Submission Form

Epping to Thornleigh Third Track Proposal. Application number SSI 5132.

I/we object to the Epping to Thornleigh Third Track Proposal and consider that the EIS is inadequate and does not address the full impact of this proposal. It will cause untold damage to the health of residents and to the fabric of the Beecroft Cheltenham Heritage Conservation Area. Do not approve this project, reconsider the alternatives and protect the community.

Figure 5.6 Cross-section and elevation - New Cheltenham Station concourse building
Note: Indicatively added to future design

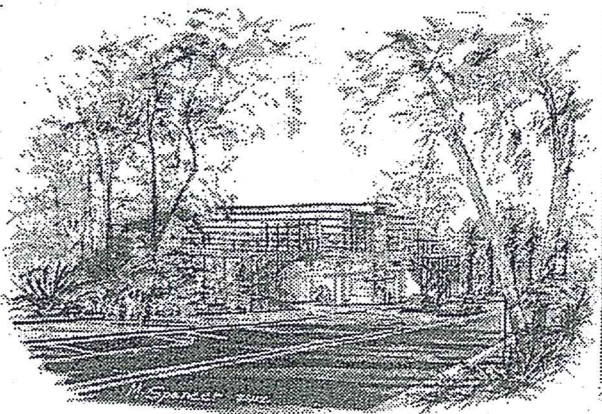
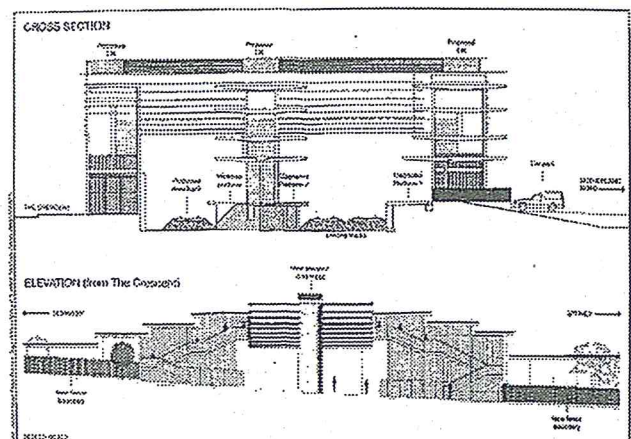
- The proposed redevelopment of Cheltenham Station shows no regard for the HCA. The visual impact of the proposed 13m high glass and steel concourse is totally unacceptable in this HCA.

Concept design drawing of proposed changes to Beecroft Station (Parsons Brinckerhoff 9/3/12). Former side platform shaded in pink.

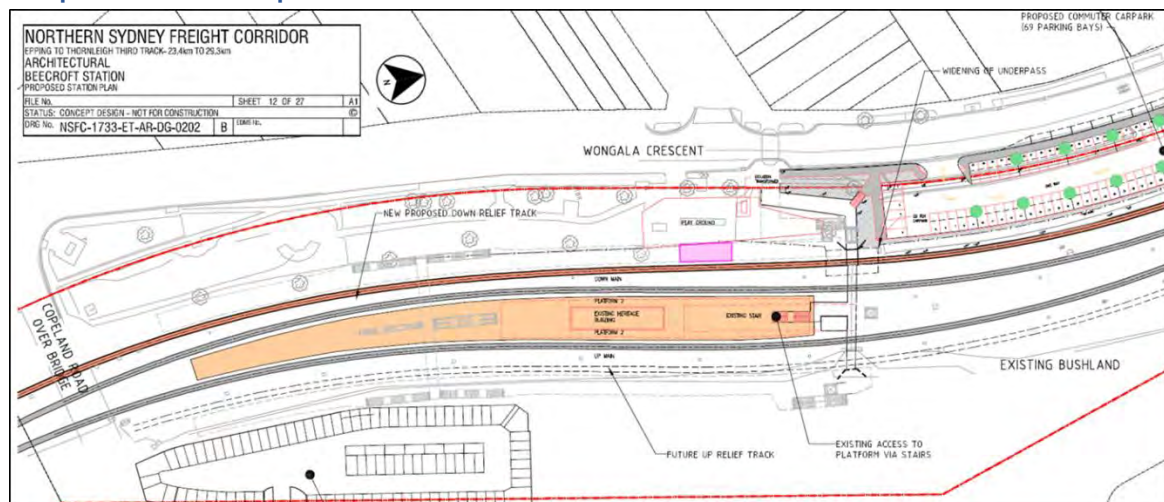
- There has been inadequate assessment of the project's impact on the fabric of the Beecroft Cheltenham Heritage Conservation Area (HCA).
- The plan given for Beecroft Railway station Precinct is vague. The relationship to the trees, playground and original 1895 platform located south of the present station is not shown. A fourth track is shown on the eastern side. The plan does not include urgently needed lifts to allow disabled access at Beecroft Station.
